Planning Department
Alan Varela, Director

May 26, 2022

Re: Bluesky Distributing - 9401 Bluewater Rd. NW
ESC Plan Engineers Stamp Date: 4/21/2022 – K09E050

### NOTES:

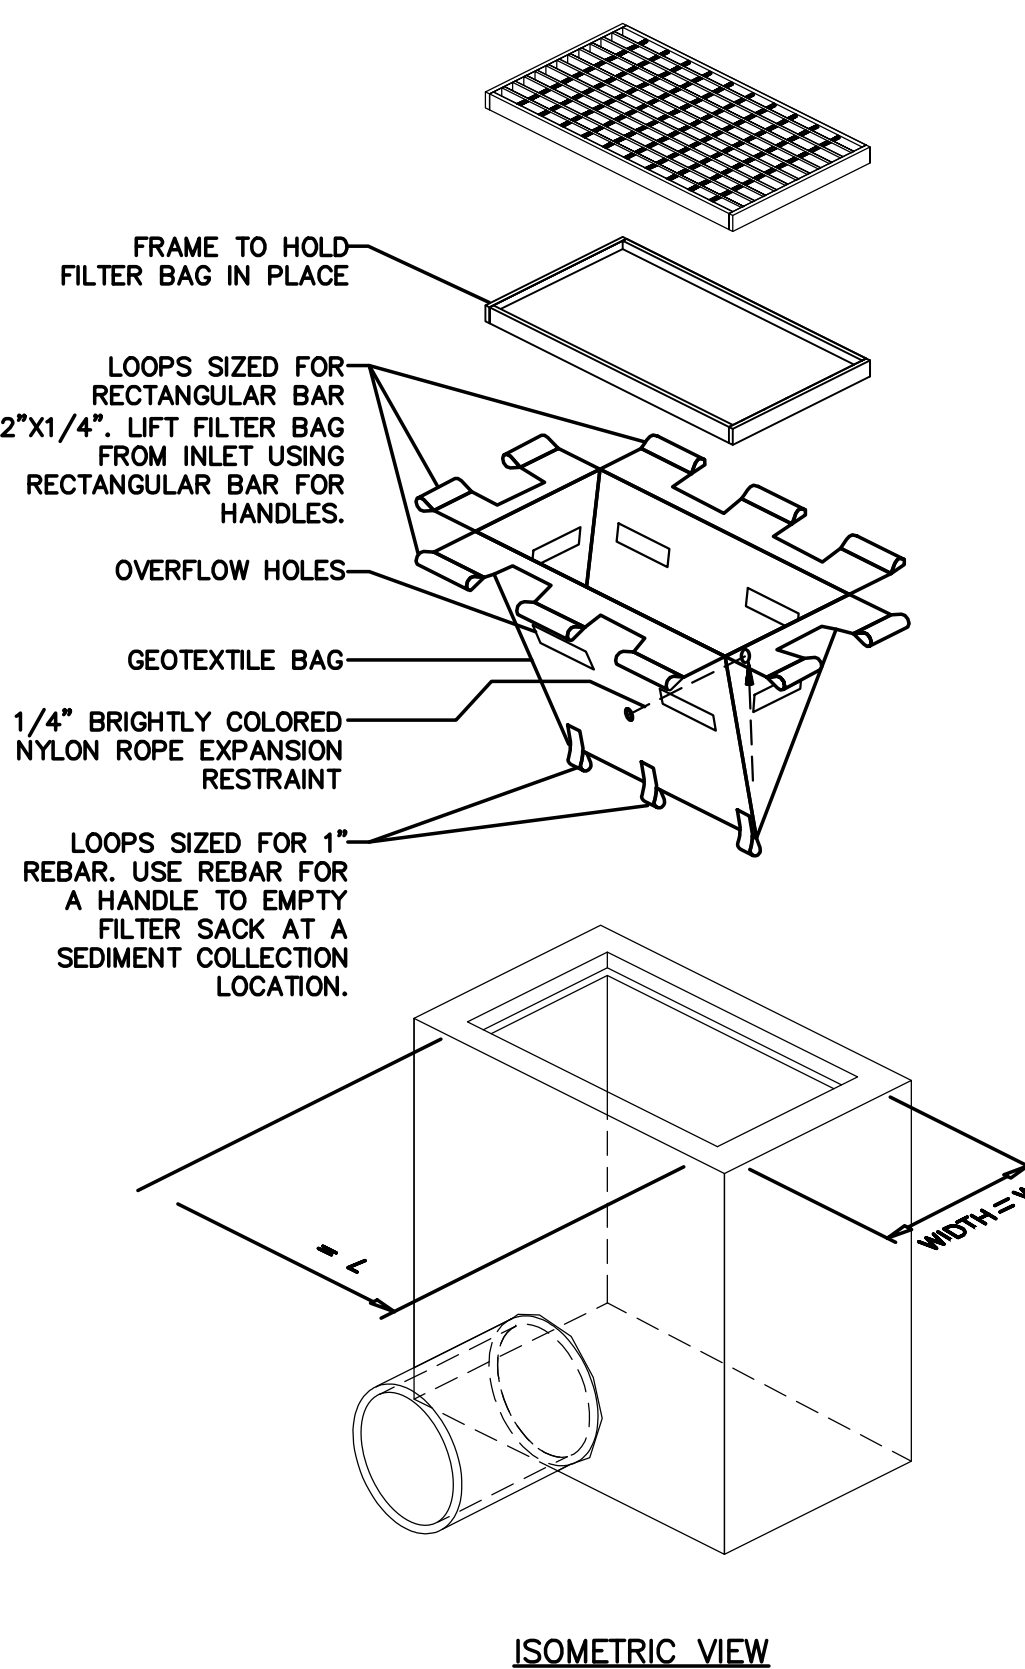
1. Aspen Autumn, LLC will be the new property owner in control of both the Work Order and the Building Permit. An NOI is required in the Property owner's name prior to approval for Building Permit or Work Order.
2. The SWPPP must include site-specific interim and permanent stabilization per CGP 9.4.1.c.i. The Landscape Plan and Work Order sheets can be used to satisfy this requirement and should be submitted separate from the ESC Plan with the application to the Stormwater Quality Section of the Planning Department and they should be included in the SWPPP.
3. Soil information – add a table with name type, particle sizes, and Erodibility factor (CGP 2.1.1).
4. The silt fence should be moved to the limits of disturbance on the south and west sides of the site to keep it out of the way of the sidewalk construction.
5. Update the engineer's stamp date each time the plan is changed.
